PORTLAND MAINE

July 21, 2011

Re: 43 Watson Street – 431 C005 – R-3 residential zone – expand front porch – permit #2011-07-1727

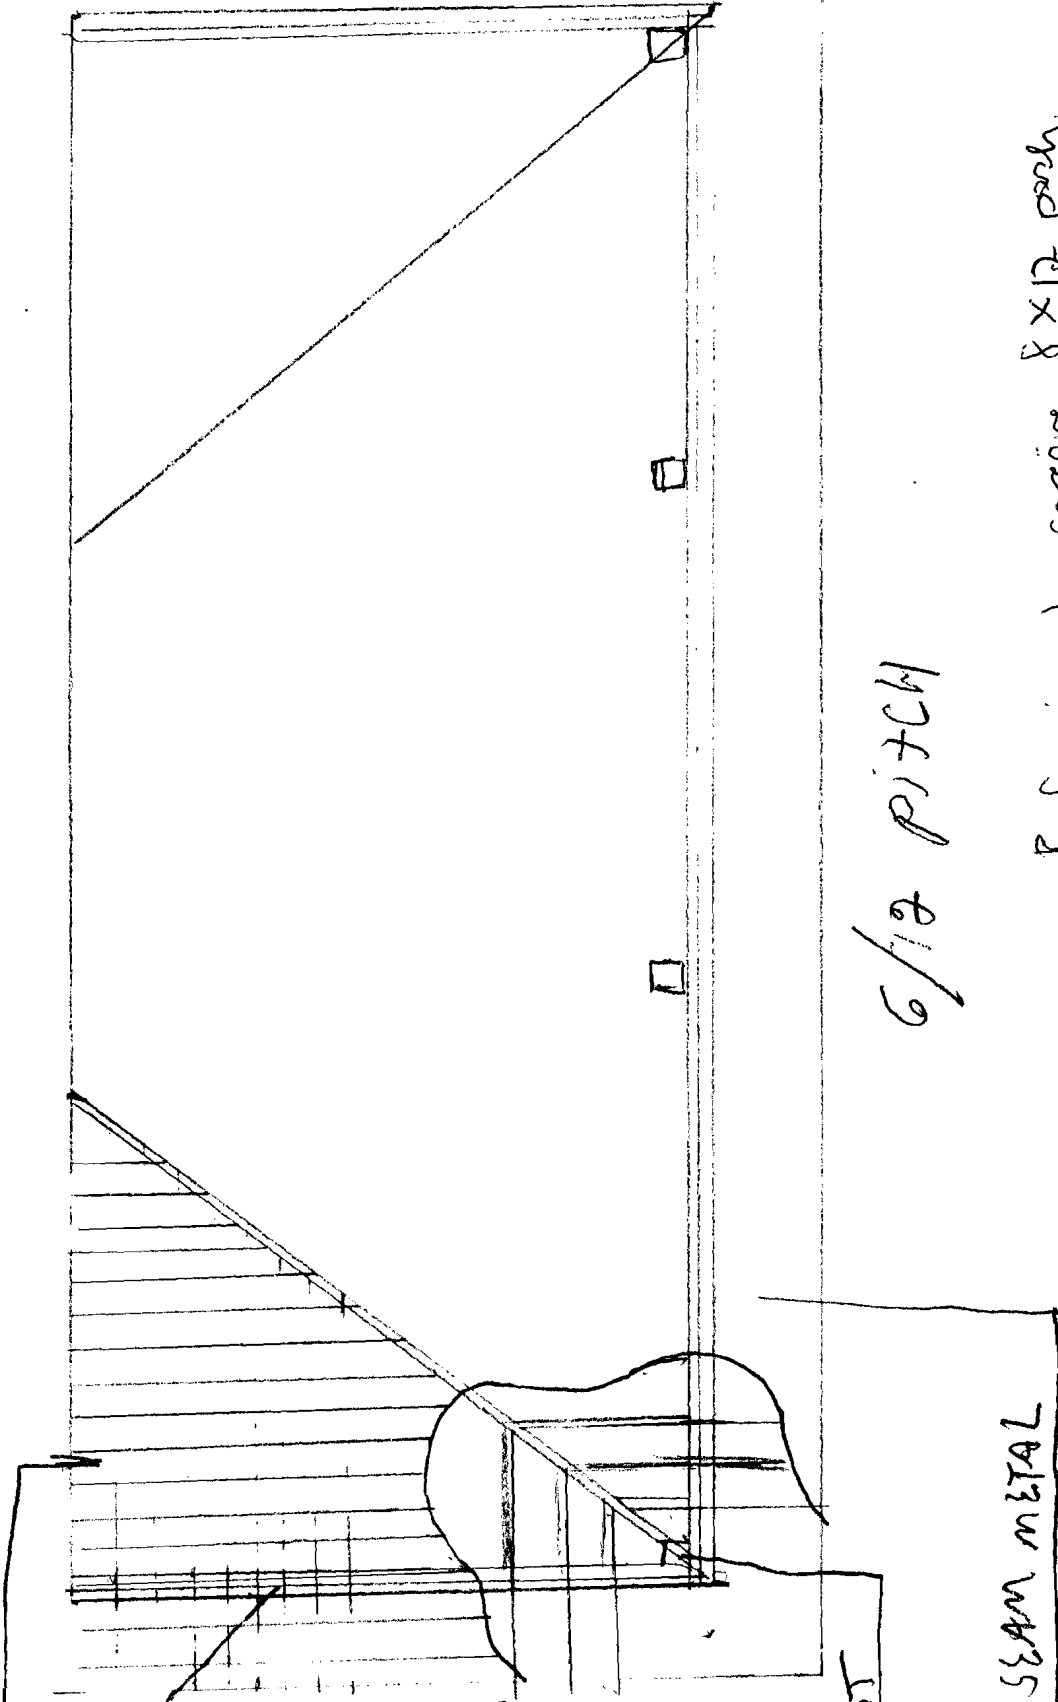
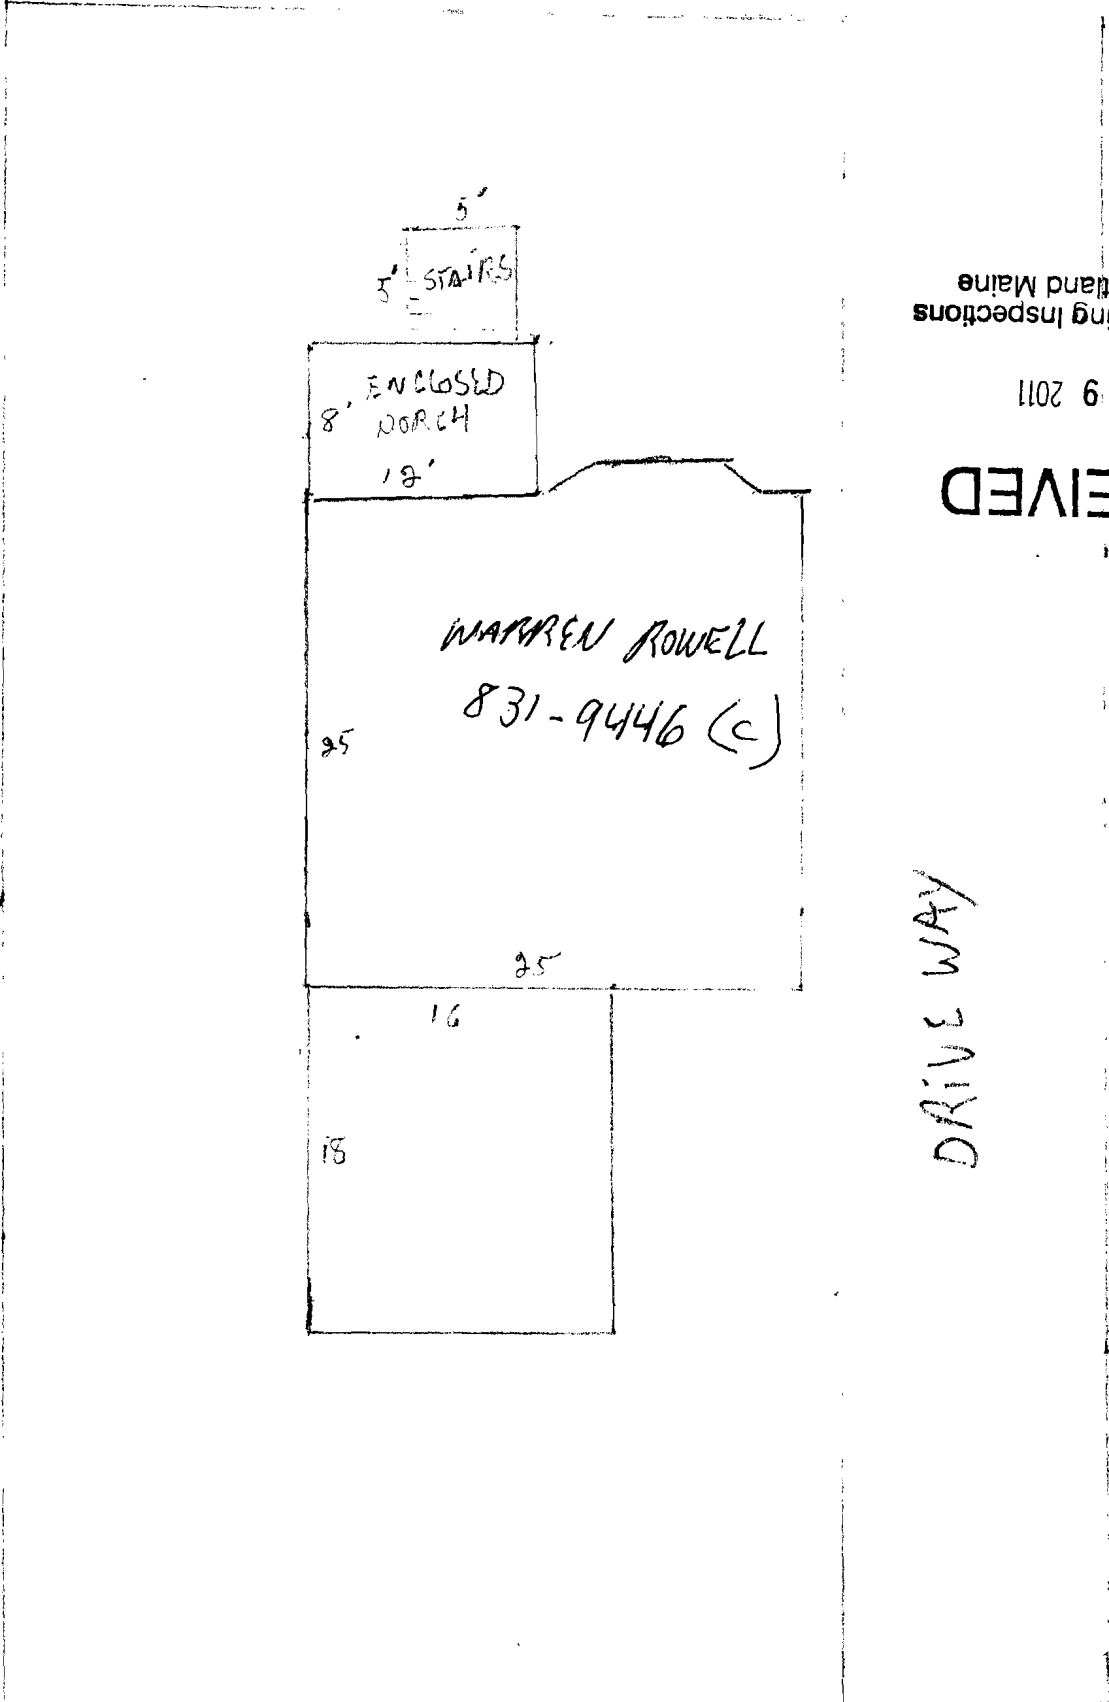
43 Watson Street is located in the R-3 residential zone. Section 14-90(d)(1) states that the minimum front yard setback is twenty-five (25) feet. Your plot plan gives the setback from the porch to the street as 16'. This does not meet the minimum requirement. Also, it is not clear if the 16' that is given is to the street or the front property line. Since you do not meet the required setback, you cannot expand your front porch. You can rebuild the existing permitted front porch which our records show to be 8' x 12'. Please submit revised plans that reflect that you are only rebuilding the front porch in the previously permitted footprint.
